DECISION DELEGATED TO HEAD OF PLANNING

Application No: H11-0754-23 **Applicant:** Mr M Ryan

Proposal: Erection of 2 bed house - approved under H11-0393-20. Modification of Condition 2 to allow amendments to previously approved plans.

Location: Land Adj London Road Long Sutton Spalding

North West Elevation

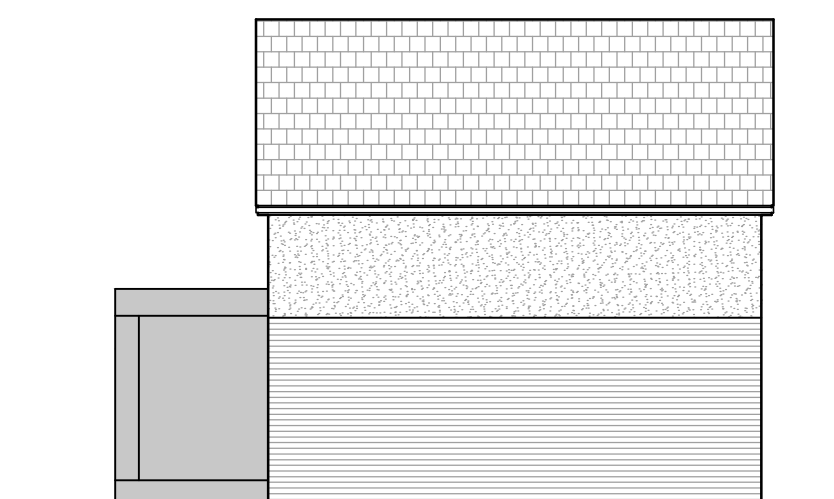
The site is higher than neighbouring land to the north-west. However, the western elevation is blank. Patio doors are located at the rear and bathroom and landing windows at first floor level. Any

overlooking from this elevation would be oblique, plus 1.8 metre high fencing is proposed along the common boundary to alleviate overlooking/privacy issues.

Proposed Section 1:100

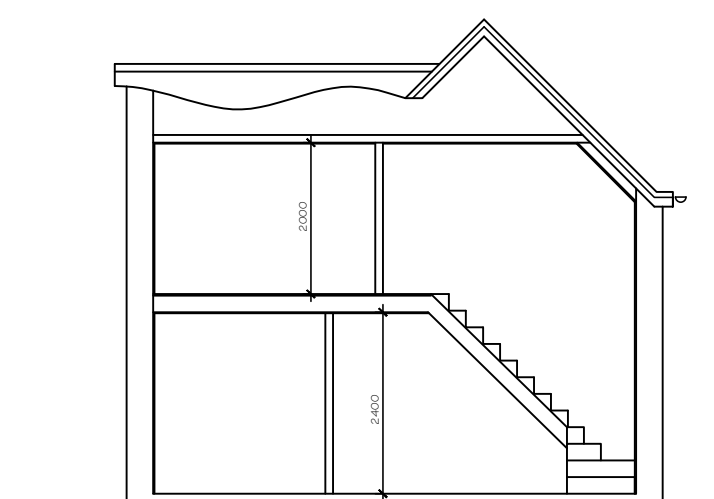
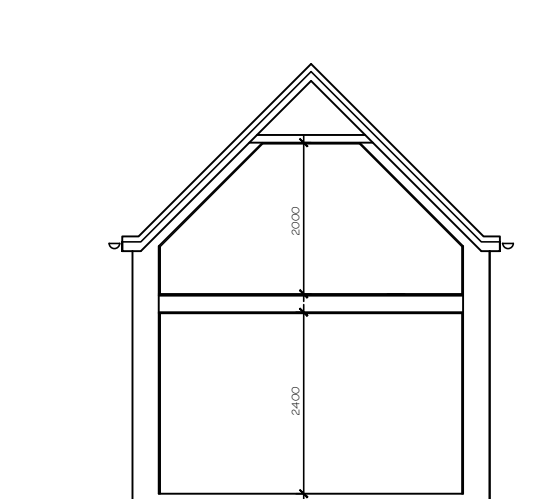
The current application includes a slight increase in height of the rear single storey flat roof element from some 2.5m to 2.85m approximately, presumably to improve internal living conditions. This is not considered excessive, plus the rear element is some 1.4m from the boundary with No. 19 London Road. Whilst there would be some blockage of direct light to the neighbouring property it is not considered to be such as to justify refusal.
